CITY OF ALBUQUERQUE

June 30, 2017

**Re: GAHP Casa Feliz
421 Espanola Street SE
Requested for Permanent C. O. – Not Accepted
Engineers Stamp Date 12/18/15 (L19D073F)
Certification dated: 6-7-17**

**A1 ENLARGED SITE DRAINAGE PLAN - BUILDING H**  
1" = 10'-0"

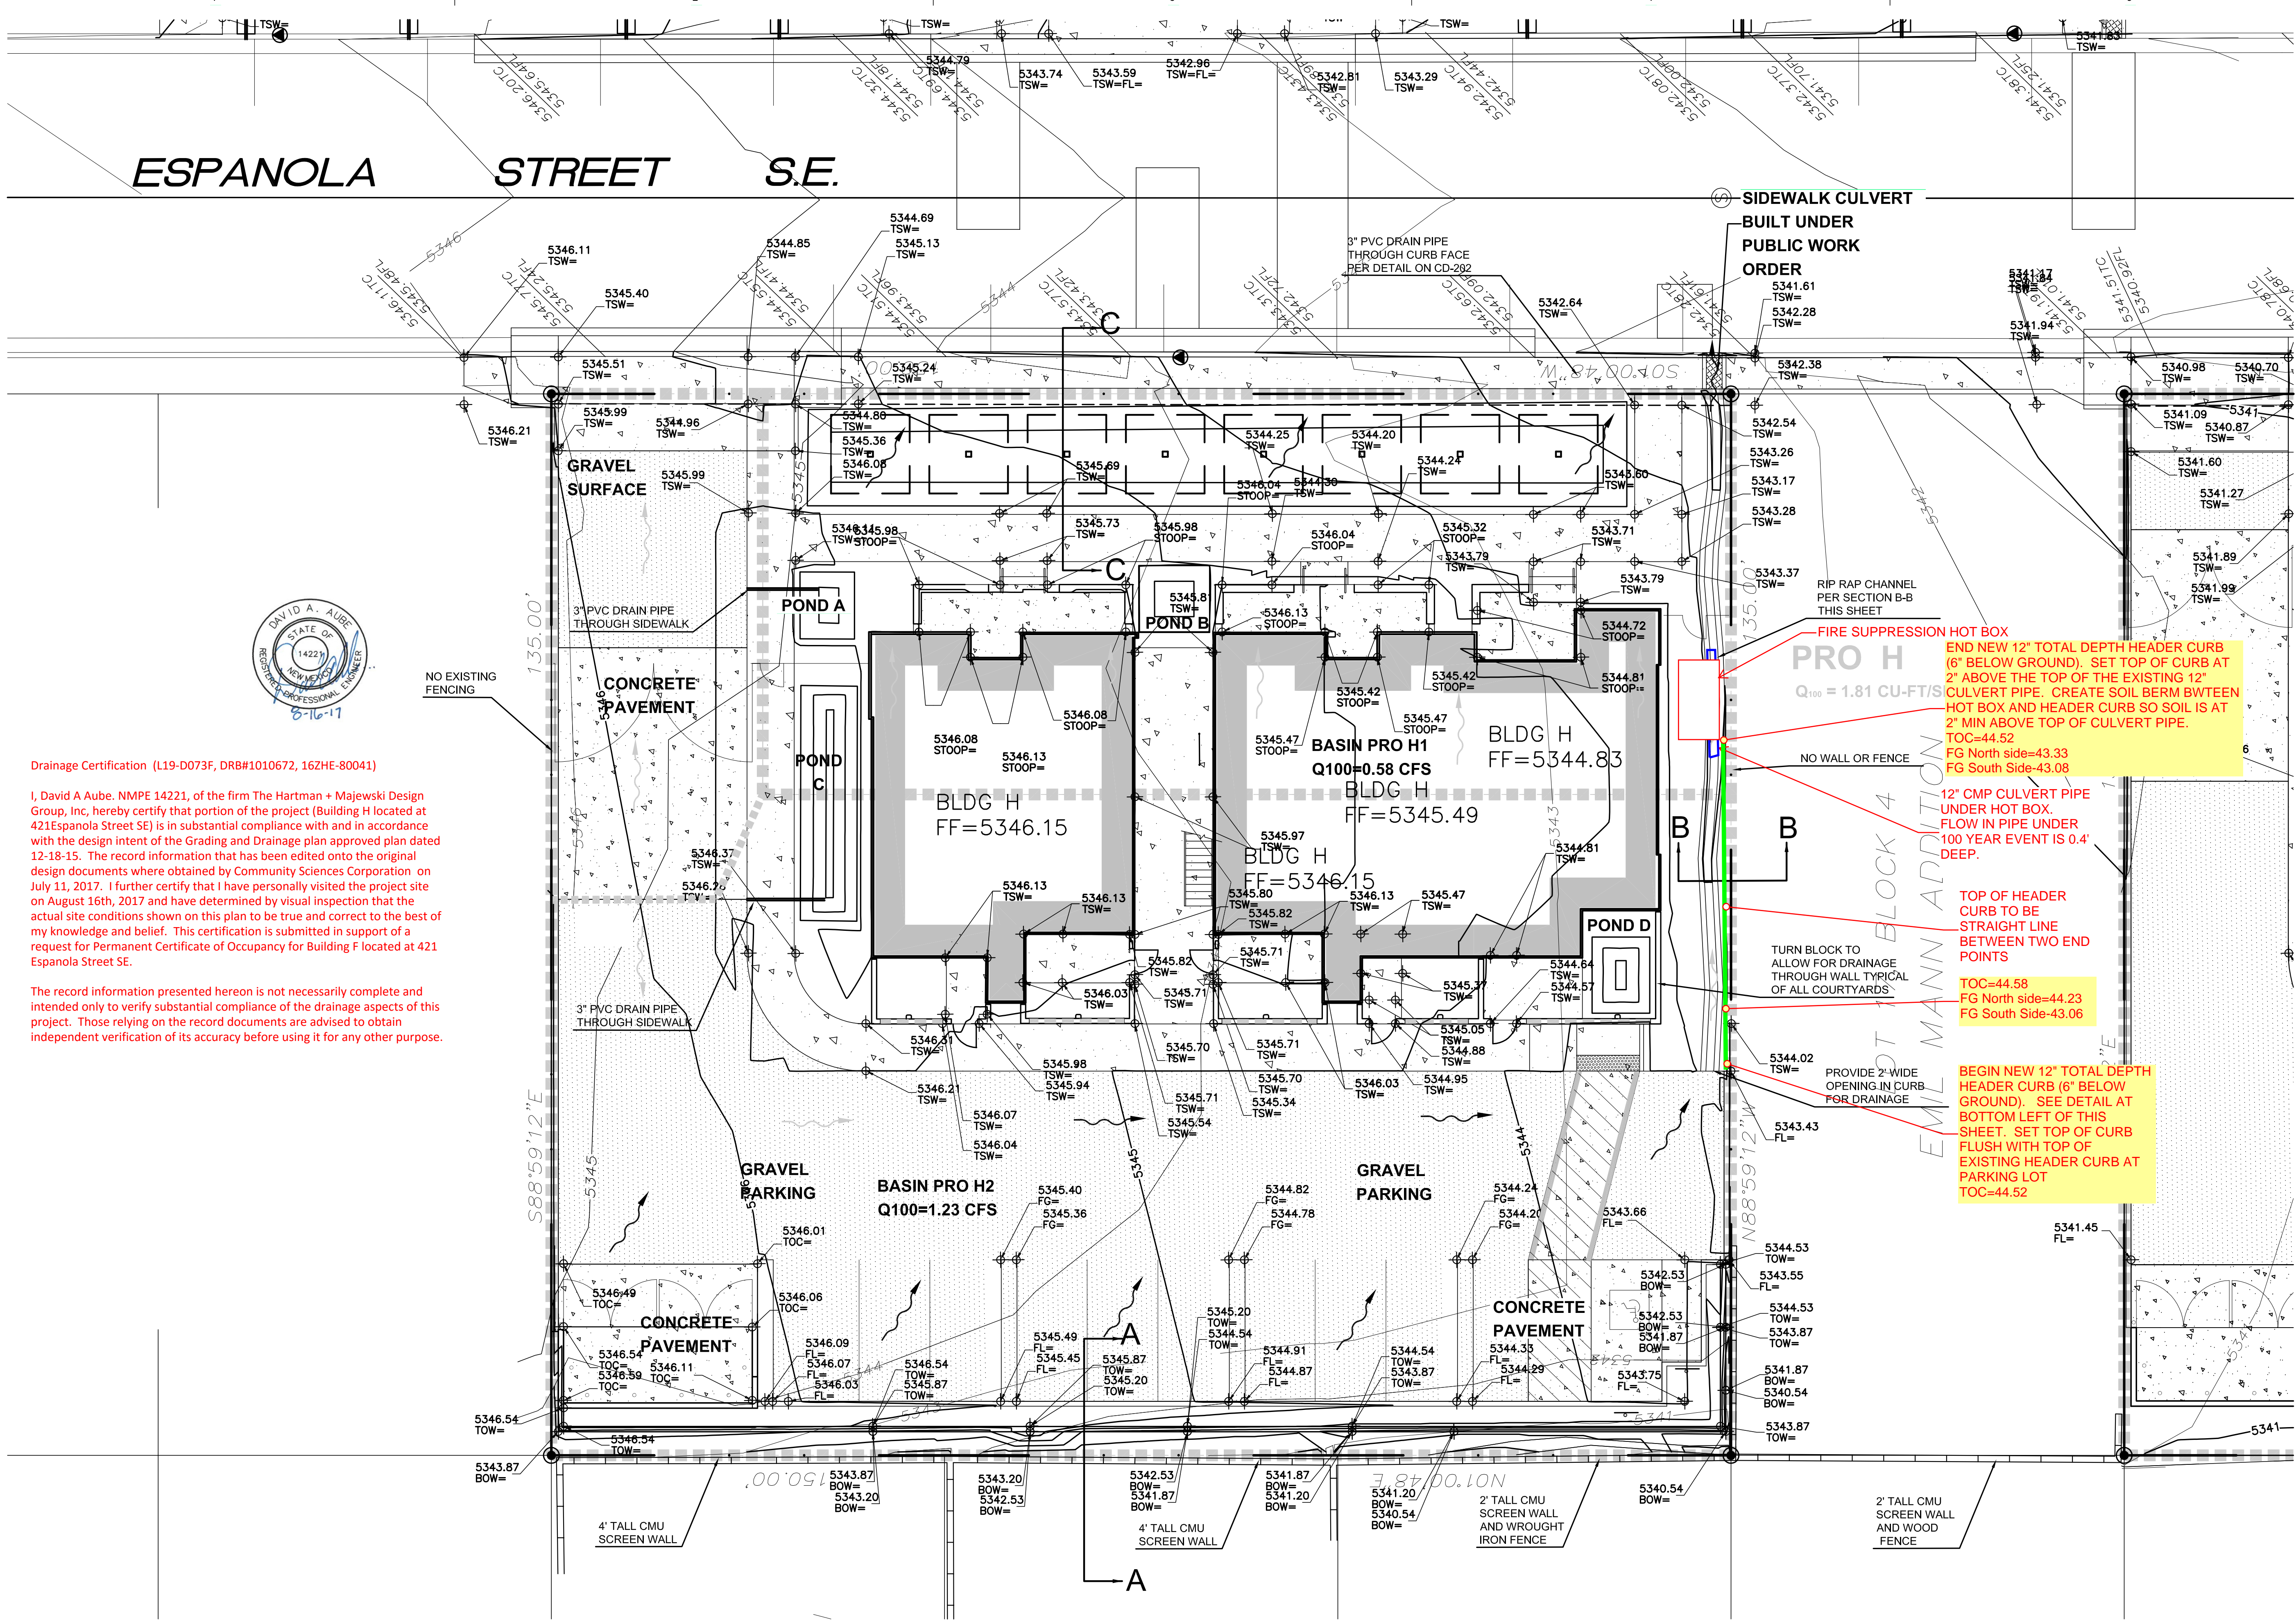
1. The swale on the south side of the site is inadequate to prevent cross-lot drainage and this project placed about 1' of fill along the property line piled against a wooden fence. A retaining/flood wall is recommended to prevent drainage from entering the adjacent lot.

2. The calculations for the pipe and side yard swale need to be revised and constructed to prevent cross-lot drainage. The pipe should be analyzed as a culvert instead of the normal depth calculation in 6-28-2017 submittal. The headwater depth on the 12" culvert is about 0.9'. Manning's "n" value in the channel calculations also needs correction from 0.025 to 0.045 for rip-rap.

3. Using the revised capacity calculations please provide a swale with at least 4" freeboard to insure that drainage from this site will not enter the adjacent property. The adjacent site is particularly susceptible to flooding so please make sure that no drainage from this site will enter that property.

Please revise the calculations and add a flood wall or something on the property line to accomplish the grade change and prevent cross-lot drainage.
